**RE: Lot 2 Block 10 Unit 18 Volcano Cliffs
6508 Picardia Pl. NW (S.A.D. 228)
Grading and Drainage Plan
Engineers Stamp Date 11/16/2020 (D10D0003P2)**

Based upon the information provided in your submittal received 11/16/2020, this plan cannot be approved for Grading Permit until the following comments are addressed.

## GRADING AND SITE PLAN

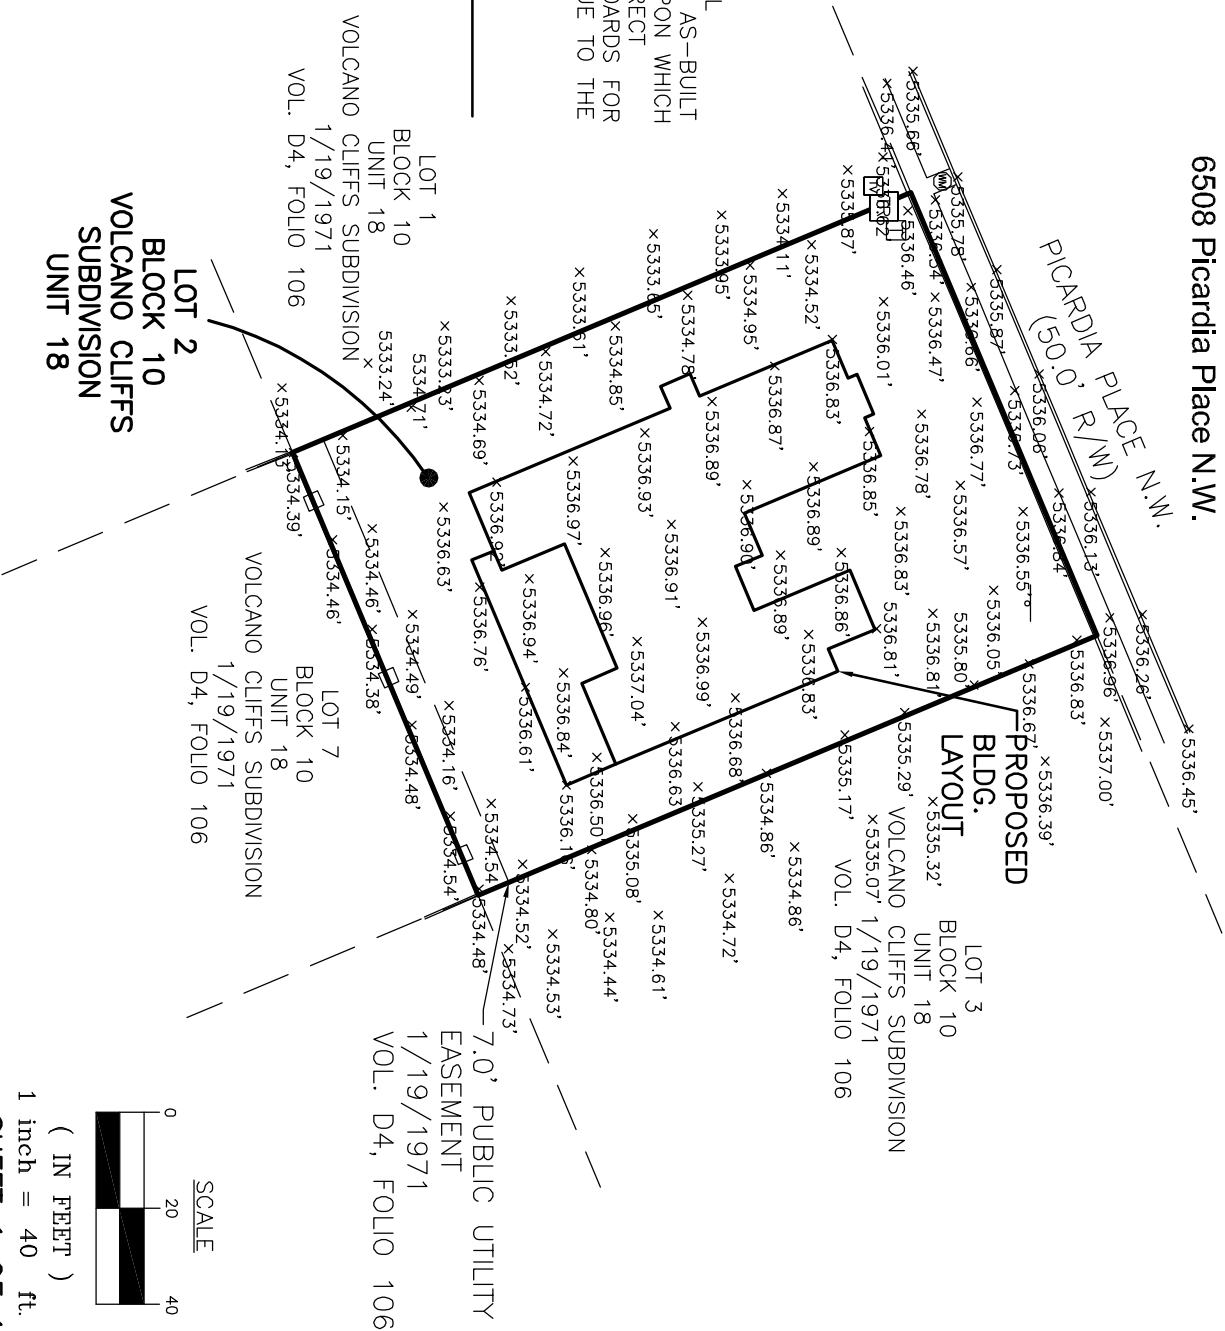
- PO Box 1293
- If a garden wall is built turn blocks should be provided 3" above finish grade.
 - The pad is too high, 6" above back of curb is sufficient; all flows need to drain to the backyard into the 7' PUE then easterly into the neighbor's yard. Ponding needs to be maintained in the PUE.
- Albuquerque
- All flows need to follow the SAD 228 Master Plan. This plan can be found in file number D10D003.
